CROWS NEST METRO: SUBMISSION ON OVER-STATION CONCEPT DEVELOPMENT APPLICATION

2.3 General Arrangement Sections and Elevations
2.3.1 Massing Elevations

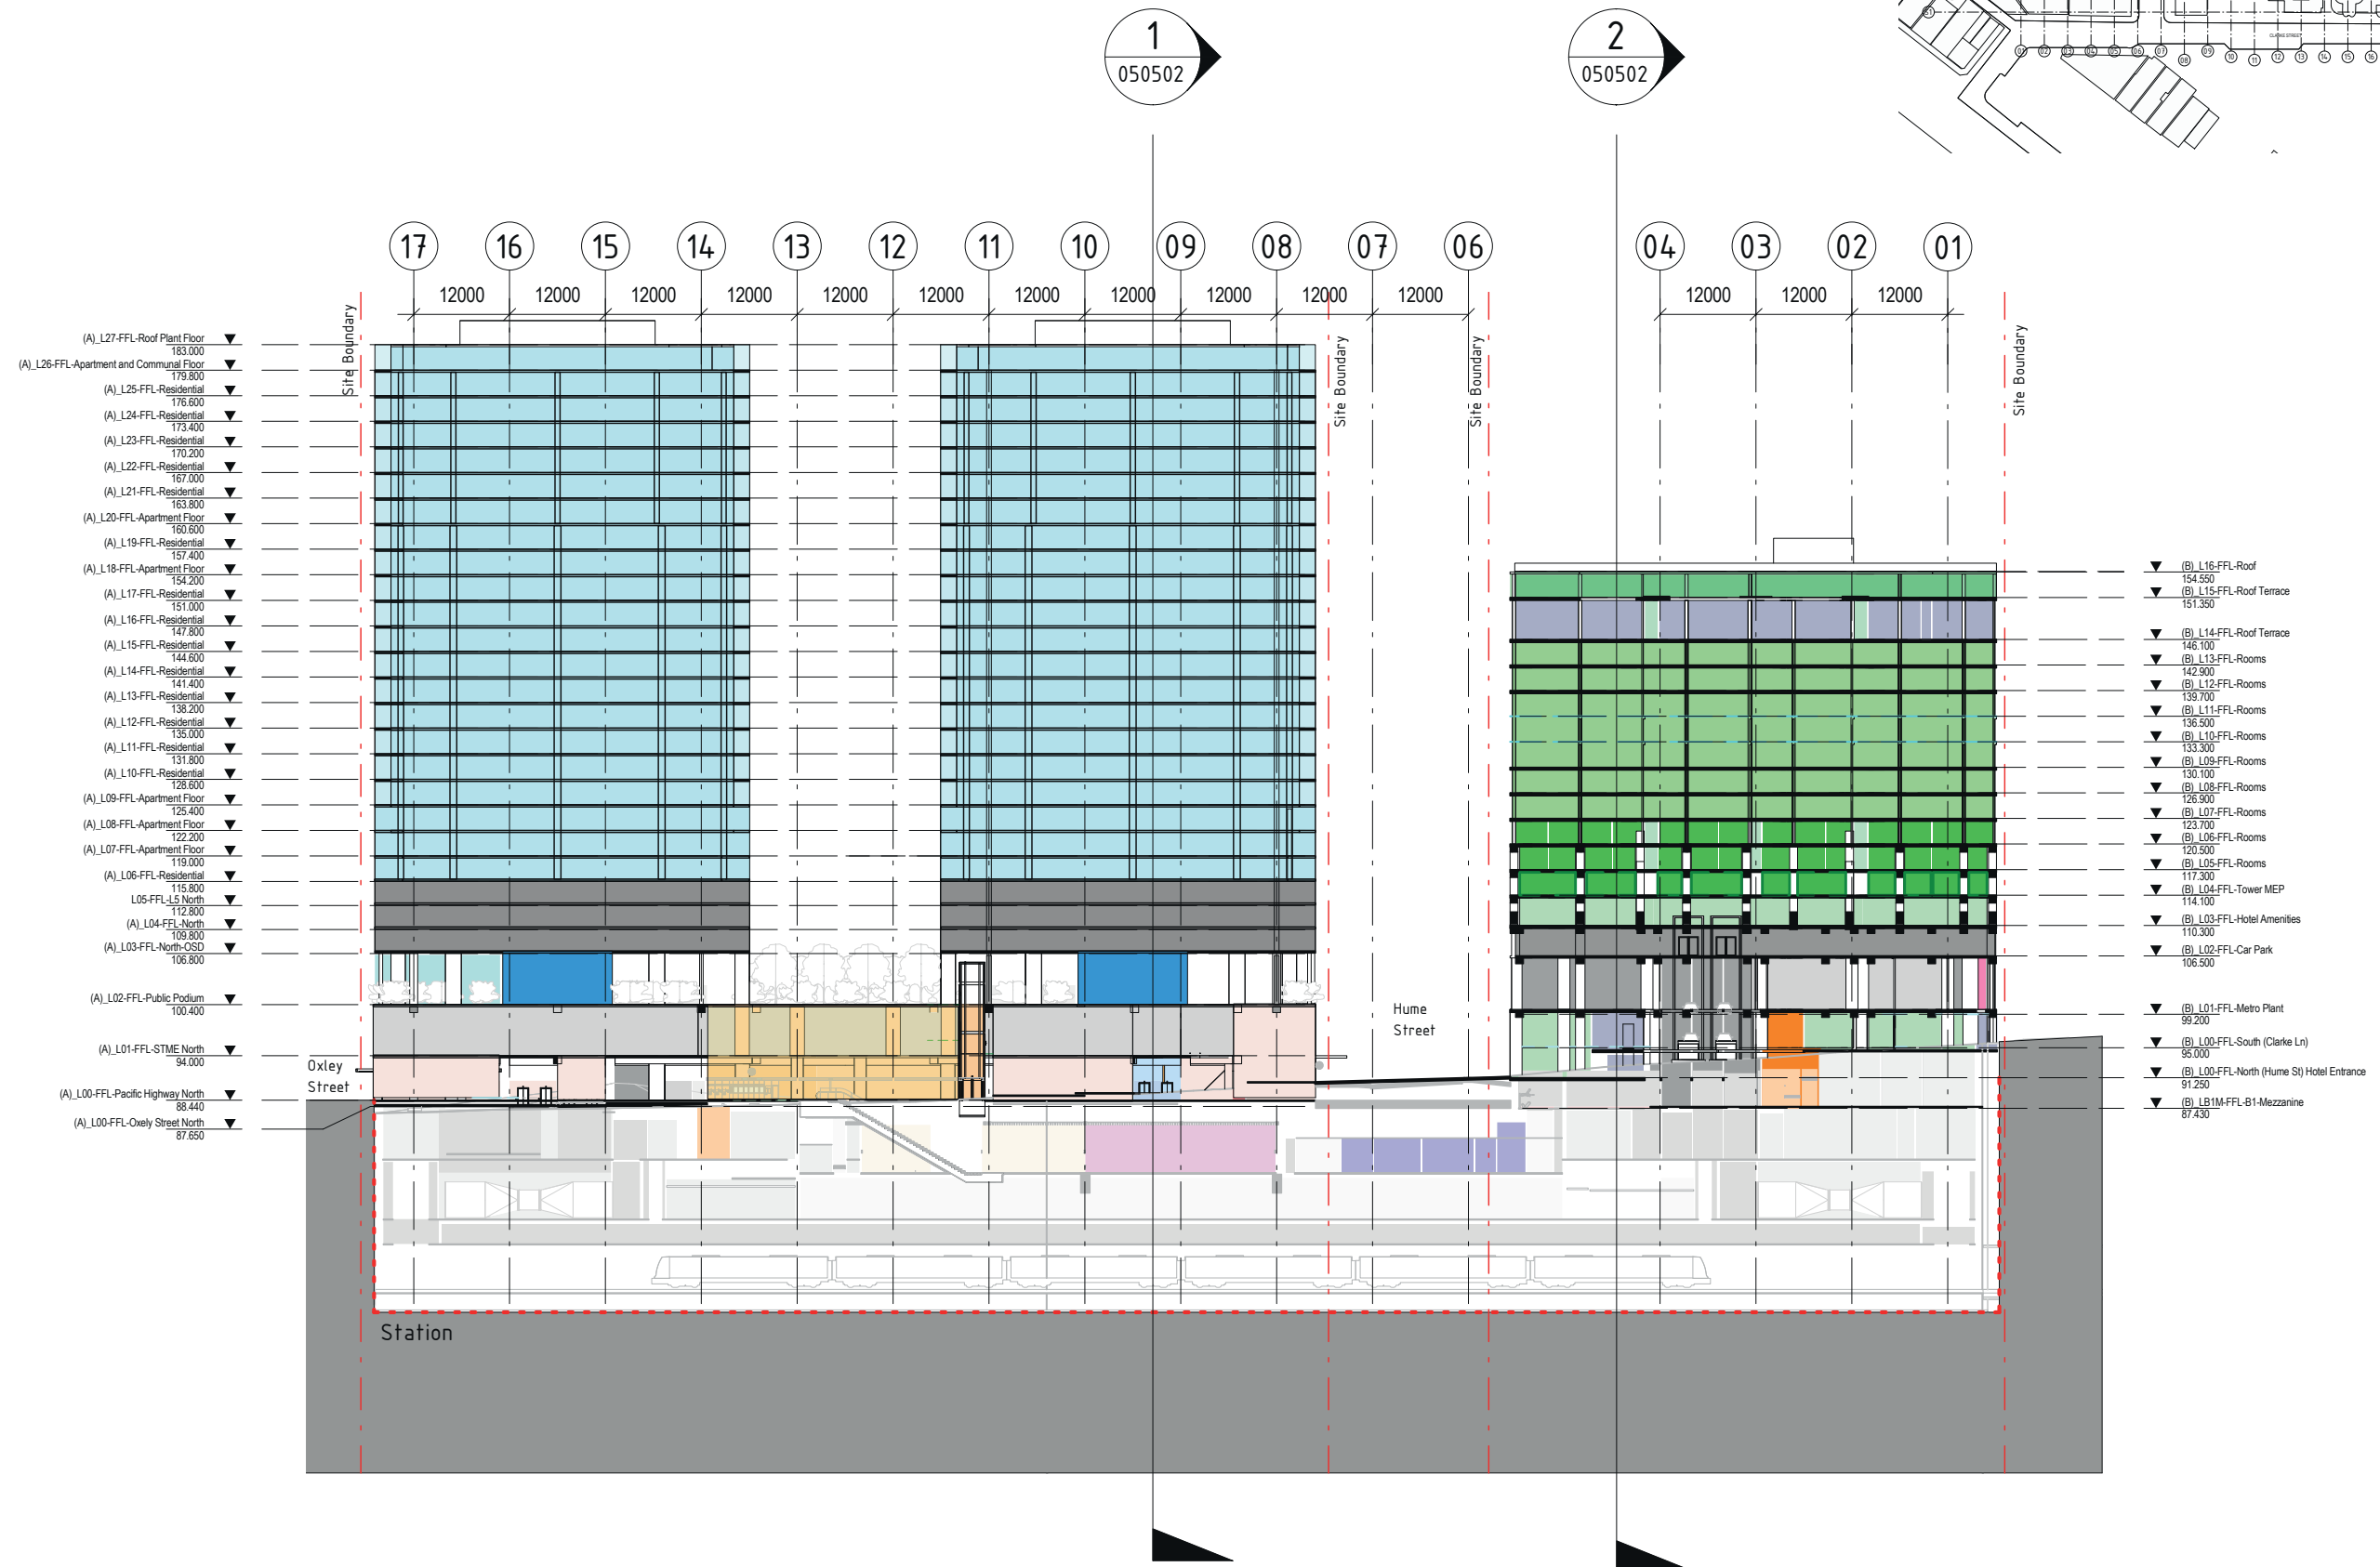
7. Generous street setbacks to allow for realistic tree canopy and mitigate wind downdraft must be a priority, particularly to the laneways and Pacific Highway. The proposal has dimensioned architectural plans, elevations and sections that OMIT the street setback dimensions. By scaling it appears the meagre setbacks are less than 3m which counteracts the Metro's supposed commitment to the public domain. Design excellence for the public domain would provide a connected green space with tree canopy from the Highway to Hume Street Park.

2.1 General Arrangement Plans - Site A
2.1.3 A-L02 Podium Community Roof

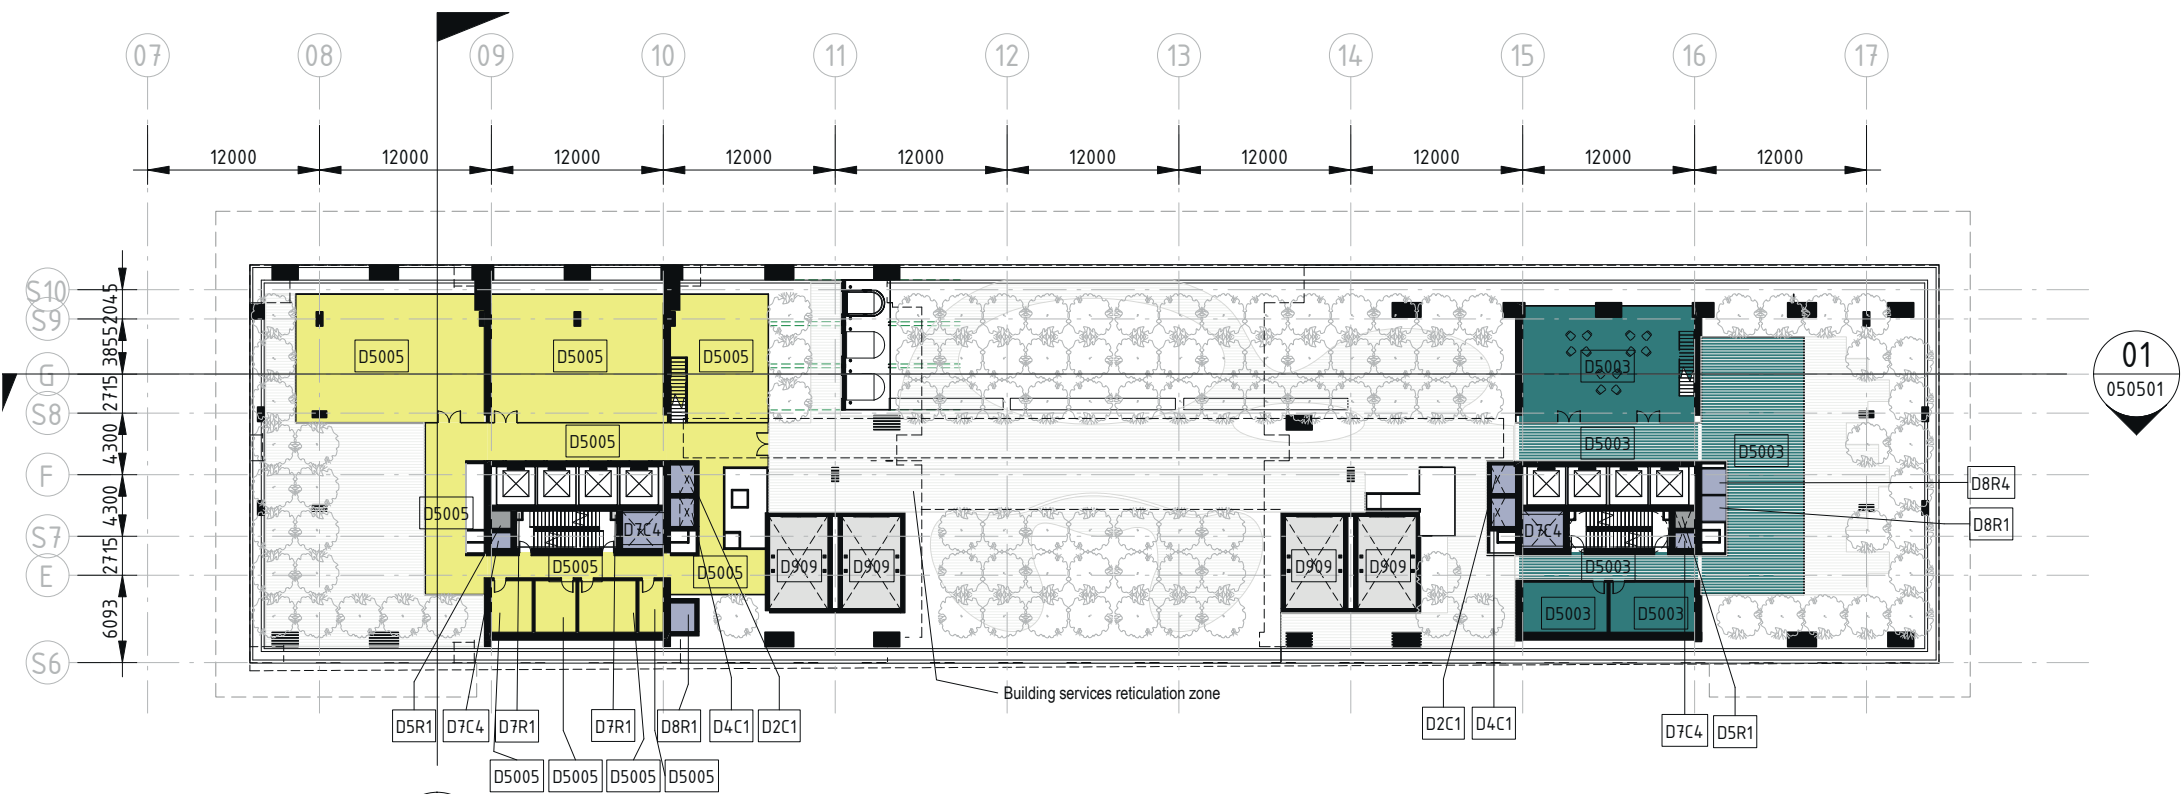
3. The buildings above the Metro must become a destination that brings people and jobs to the area – not more high-rise residential towers. The proposal pays lip service to public domain with a 'podium community roof' which will be subject to strong wind downdrafts and overshadowed for most of the day.
